# Responses to Comments

## Final Plat Comments

#### **PCD Manager Comments**

#### **County Attorney – Development Review Comments**

TOTAL ACREAGE:
LOT 1 = 20.3 ACRES
LOT 2 = 35.0 ACRES
LOT 3 = 5.0 ACRES
DEDICATION ACRES
TOTAL= 60.3 ACRES

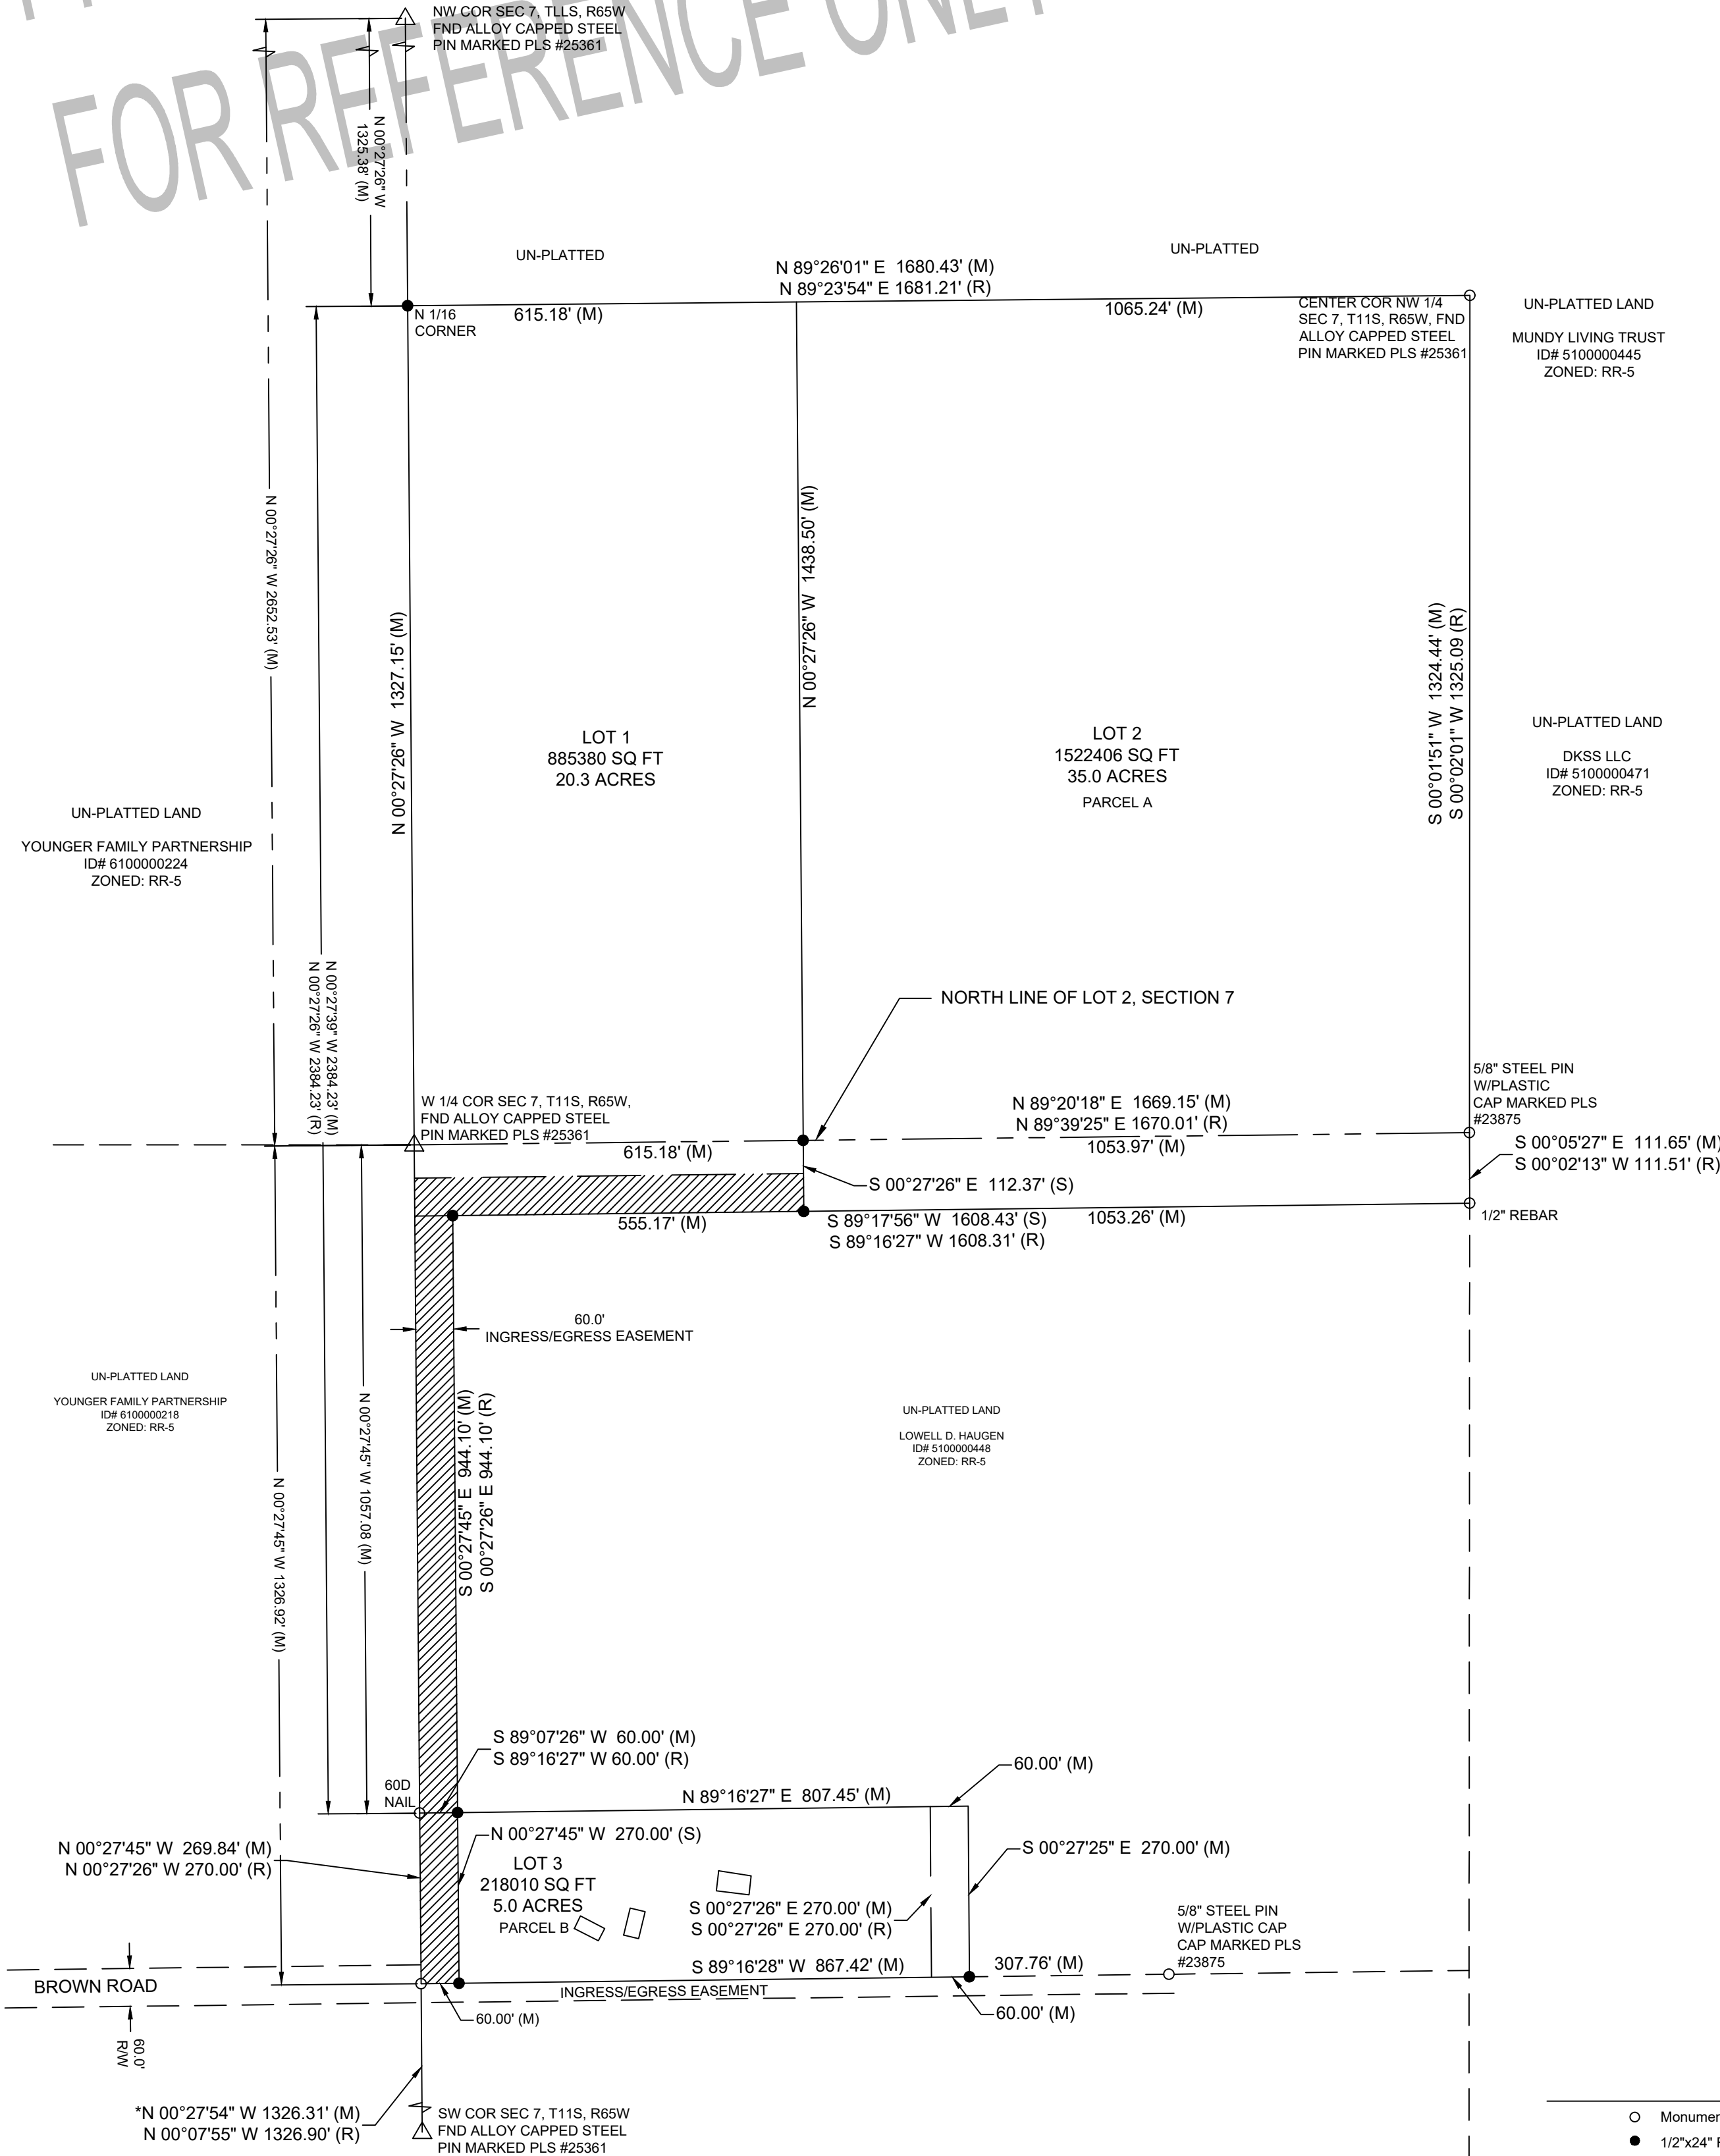
- This needs to be included in this subdivision as Lot 3. It is part of the parent parcel and is subject to this subdivision request. **Upon further discussion with El Paso County Planning Department staff, the 35-acres is still excluded from this subdivision request.**
- Include the note Soil and Geology Conditions. There are conditions noted in the report for the 35 acre lot as well as the 22 acre lot. **Note added to plat for 22-acre lot. No reference to 35-acre lot added, as it is not part of this subdivision.**

- **All this data needs to be updated to include the 35 acre lot as well. Table left as is. 35-acre parcel is not part of this subdivision.**
- **Either leave this blank or include that this is for Regional Park Area 2. Dollar amount removed and left blank.**

- **Please note – this should be a request for three lots. All property included in the parent parcel is subject to the division of land. Please update documentation accordingly. Submittal left as is. After further discussion with planning staff, the 35-acre parcel can be excluded.**
